Dear Sirs

Application M/56/15/HH
31 Sea Way, Middleton-On-Sea, West Sussex, PO22 7RZ

Proposed Elevations  
Sections B-B  
C-C  
D-D

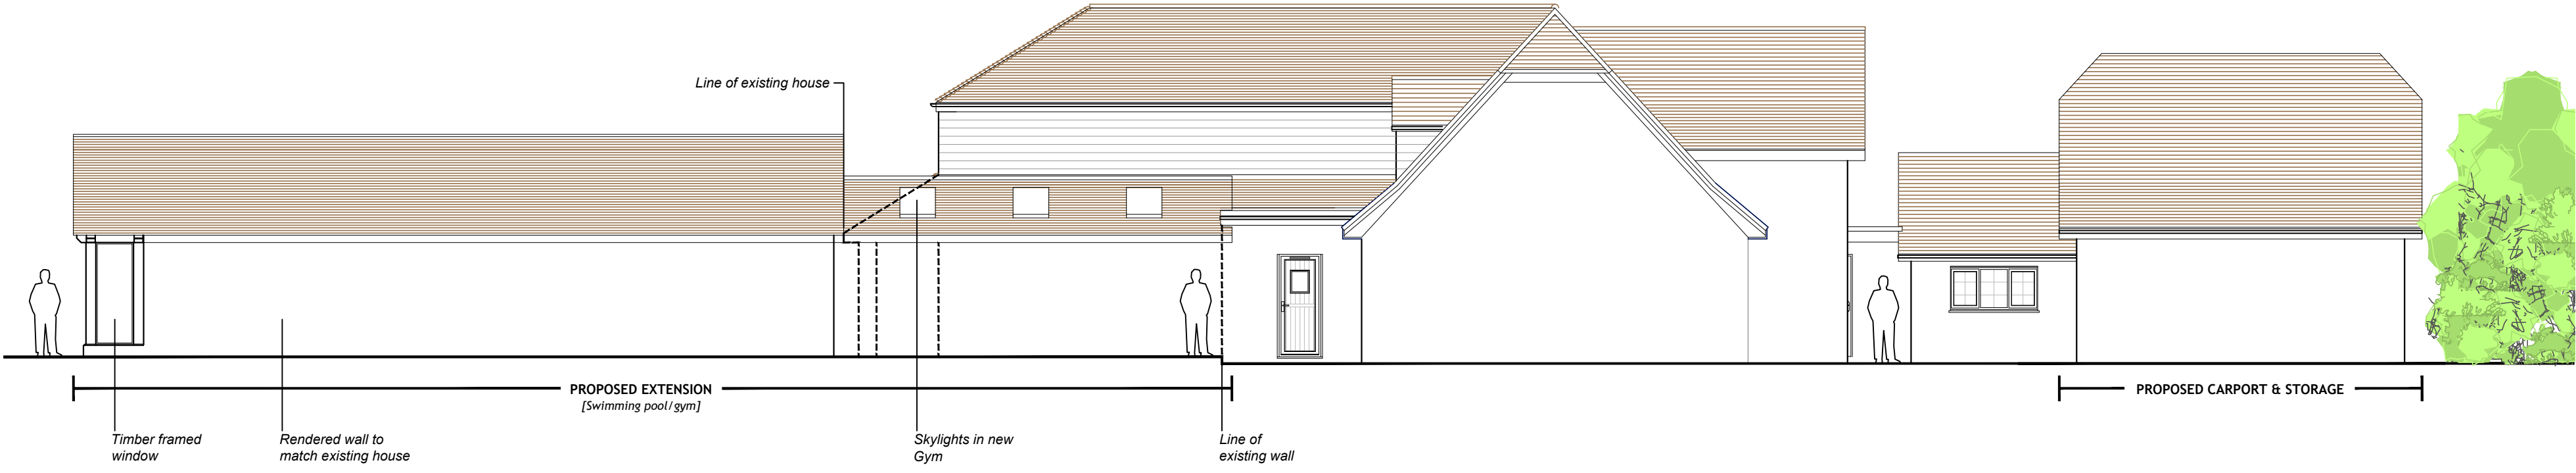
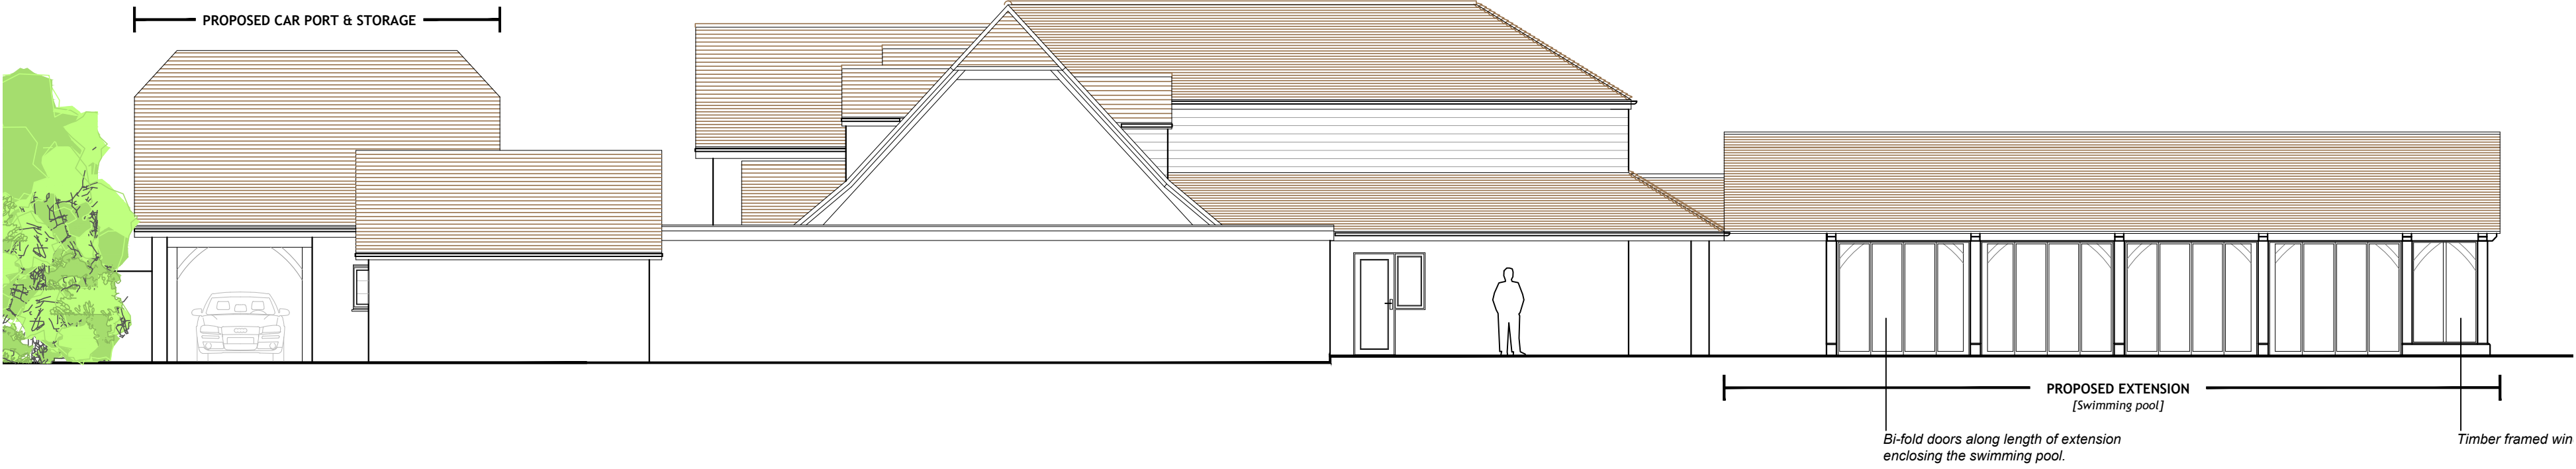
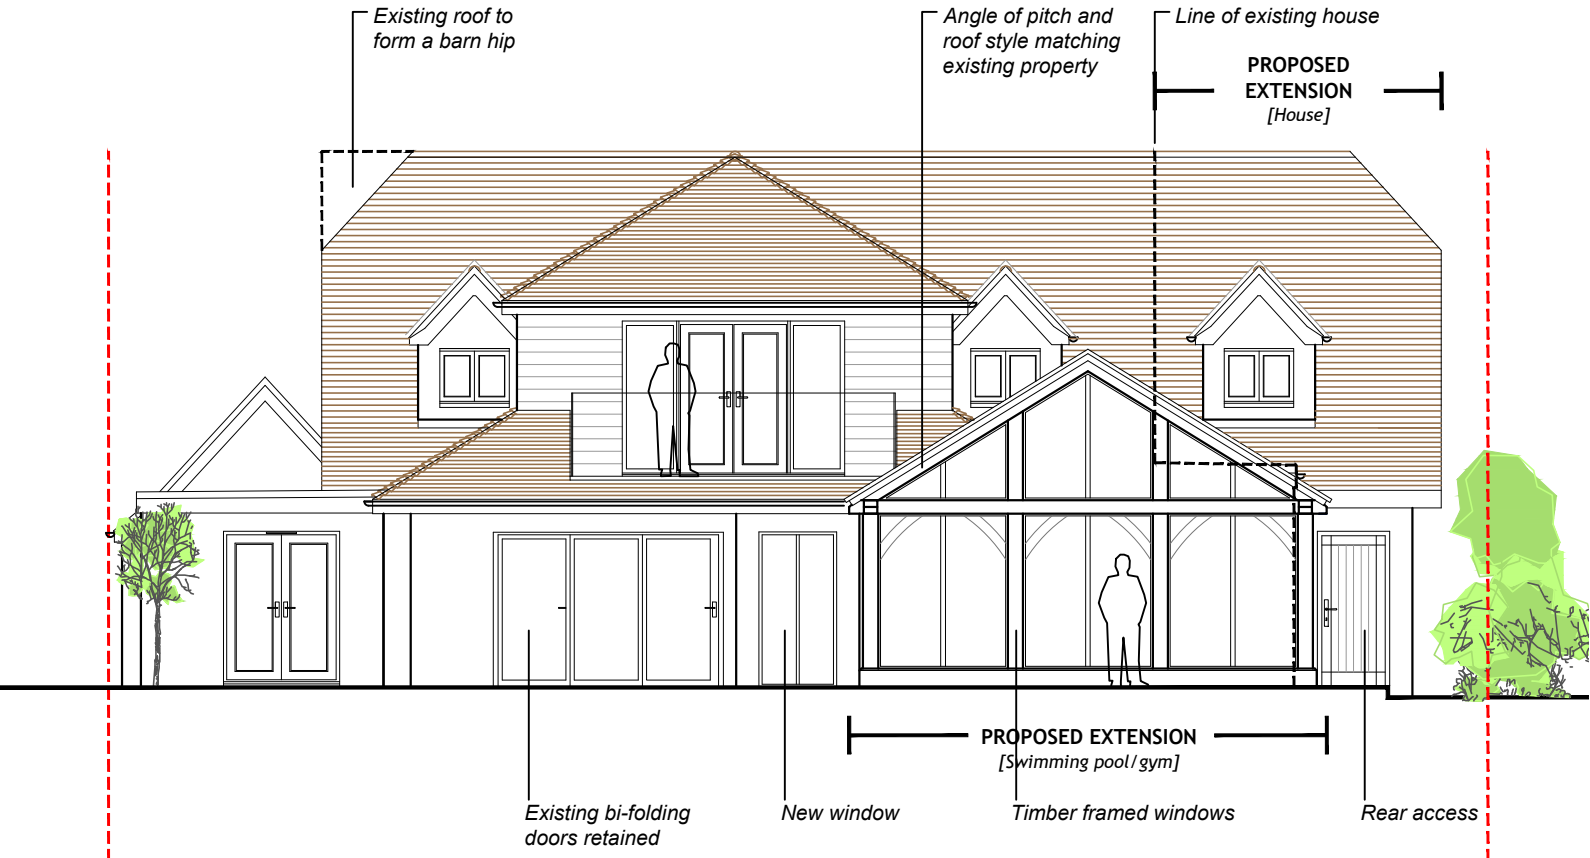
No species of hedge or shrub will survive in a **0.39m** space containing foundations and a brick wall and the view from our drive will be **6.23m** high solid block (refer to East Elevation dwg 14039/05). The garage would greatly reduce the area of front drive and restrict the parking area and turning circle, for a property of 5 bedrooms probably with a minimum of three cars possibly leading to on street parking for visitors.

The proposed swimming pool extension has a ridge height of **4.47m** and a length of **15.5m** making it both extremely high and long and very bulky. With the proposed other extensions and proposed garage, if approved, nearly **48m** of my west boundary will have a structure built up against it, that is approximately 70%. The small south west section of our garden

Should the hedge between the two properties, that is claimed to form a visual screen, survive the construction process it is only 3m tall and will not really obscure the 15.5 x 5m bulk of the pool. The window on the south east corner of the pool will also look directly into our garden again affect our privacy.

Proposed Floor Plans
- Ground Floor
- First Floor
- Roof Plan

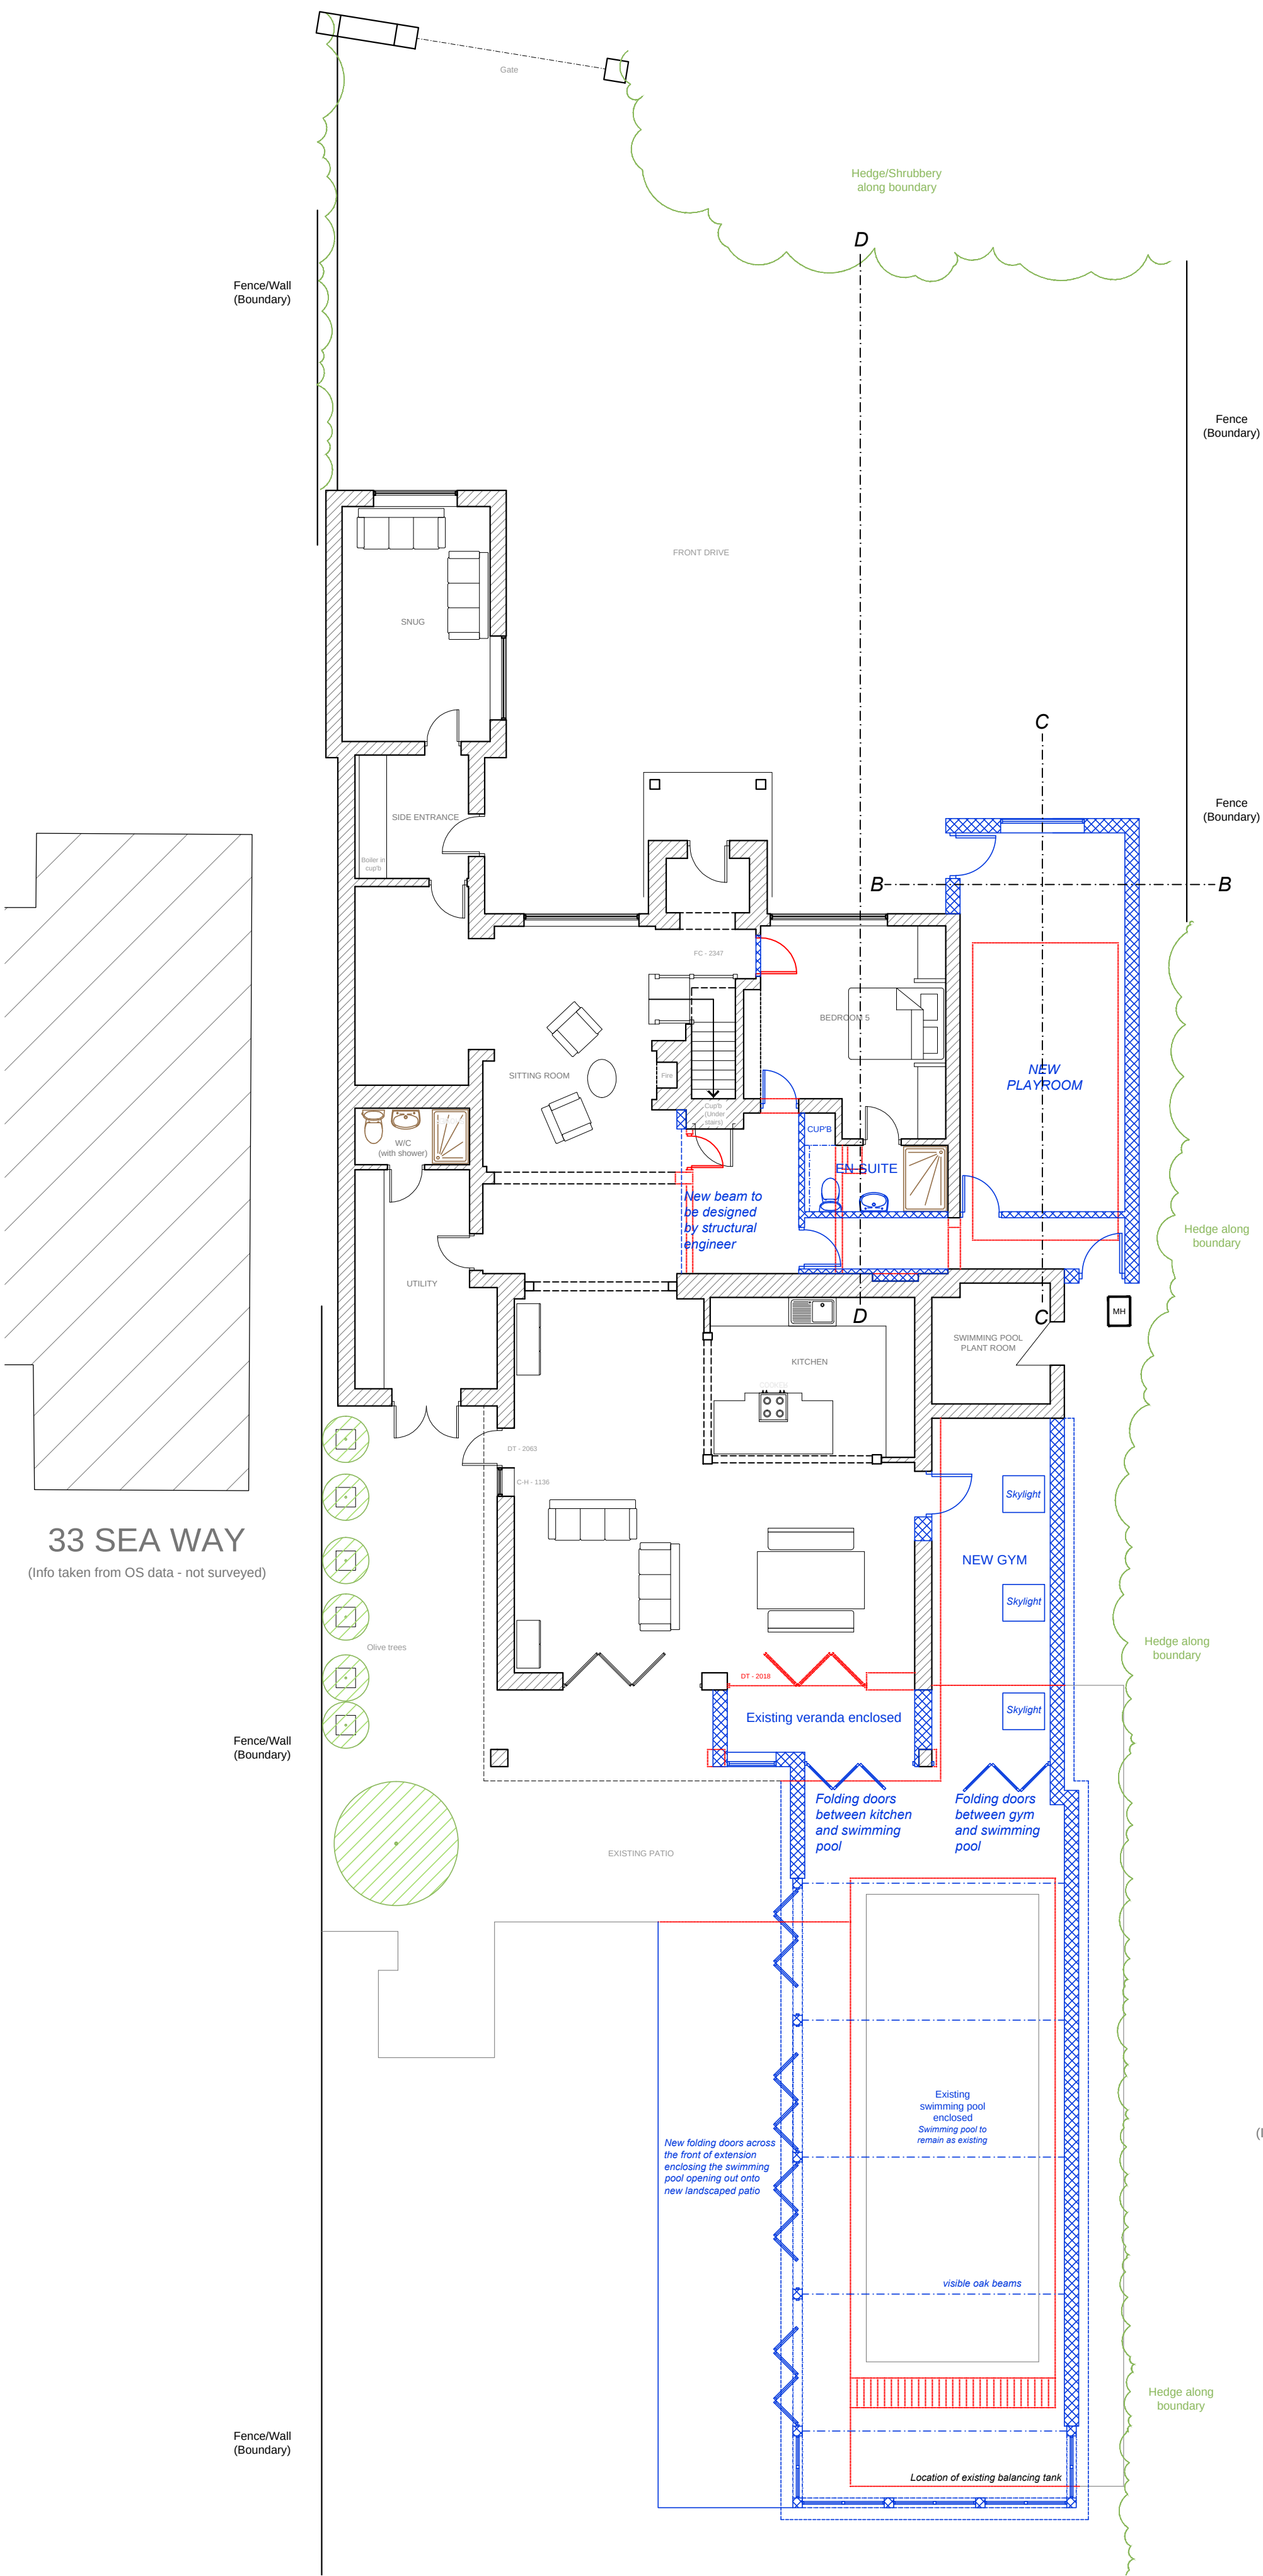
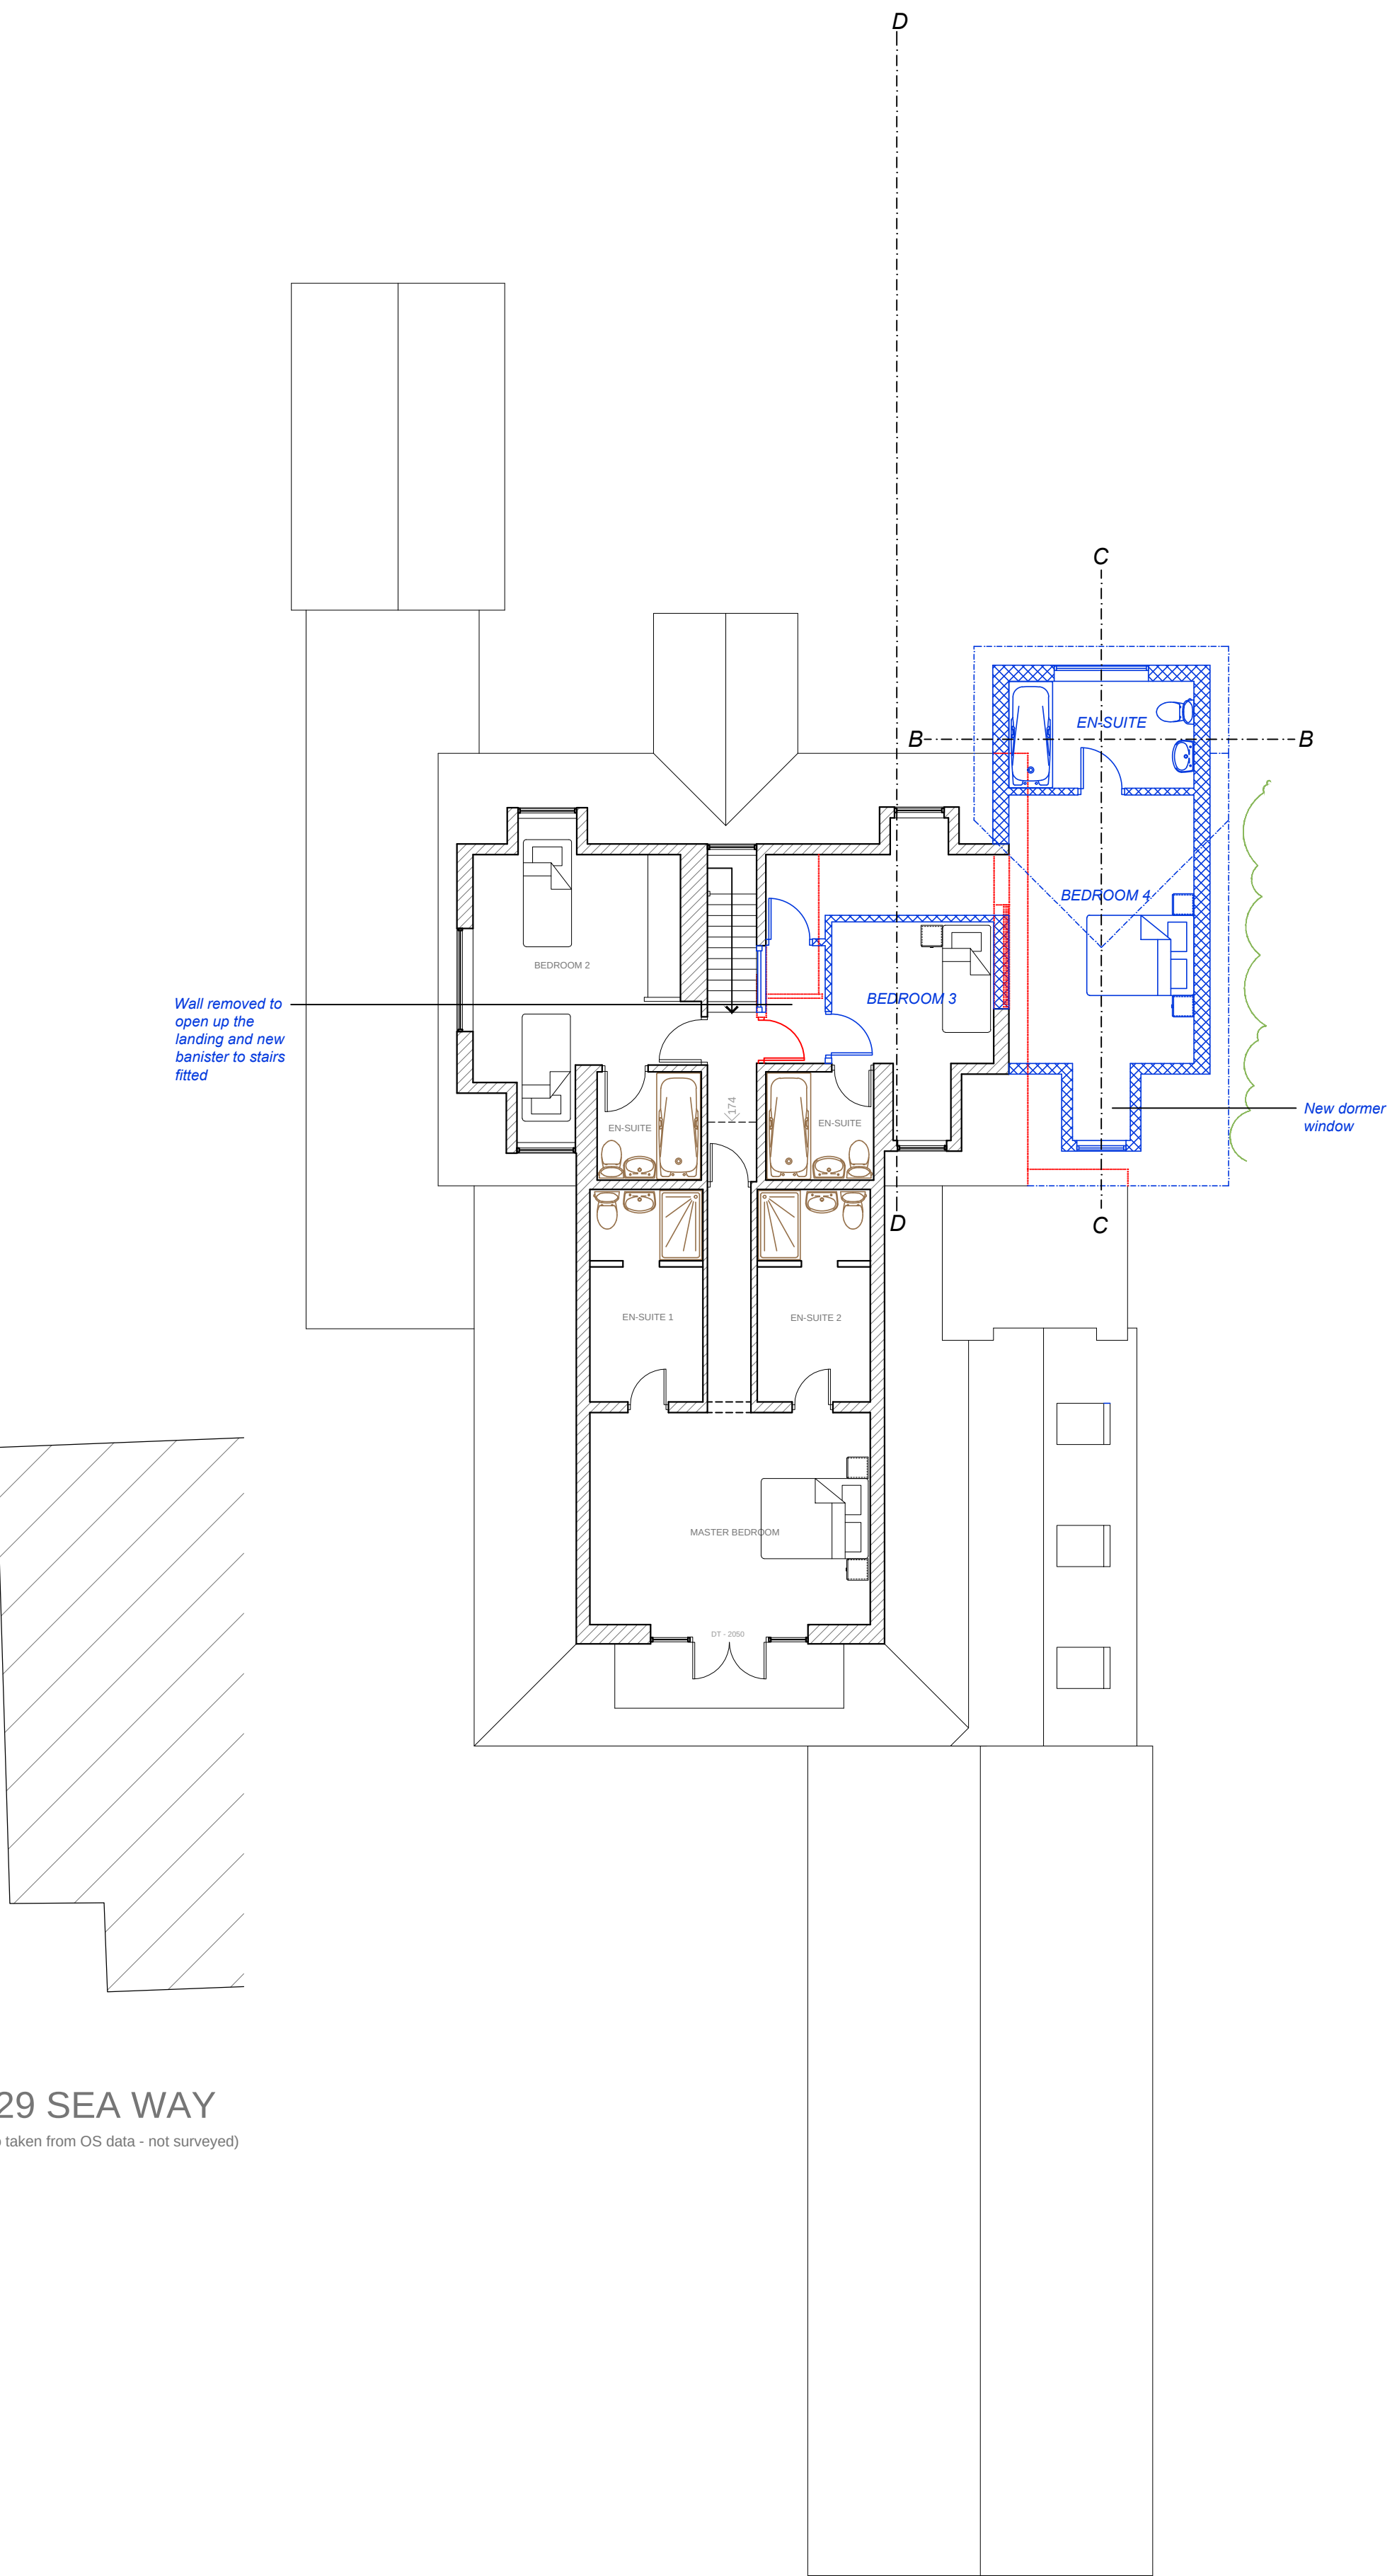
The Design and Access Statement in section *4.4 Amount*, states the ground floor footprint of the Main house is **208.7m²** and then states the proposed ground floor footprint will be **242.2m²**.

Planning applications are to be judged on an individual basis but also viewed against the previous developments on the site and it would appear that No. 31 has been evolving vertically from bungalow to house and now horizontally to fill the site from each neighbour's boundary. This two storey side extension will dominate our house overshadowing our front windows and entrance foyer particularly the evening sunlight.

The 1m side access does not take into consideration the 0.3m overhang to the verge of the roof creating an overbearing structure right on the boundary and again reduce the space between properties. There is also the loss of privacy and overlooking from the new first floor dormer window to the 5th bedroom which looks directly down into our front facing window. The loss of light particularly to this window will be dramatic and we will be assessing any “rights of lights” issues separately.
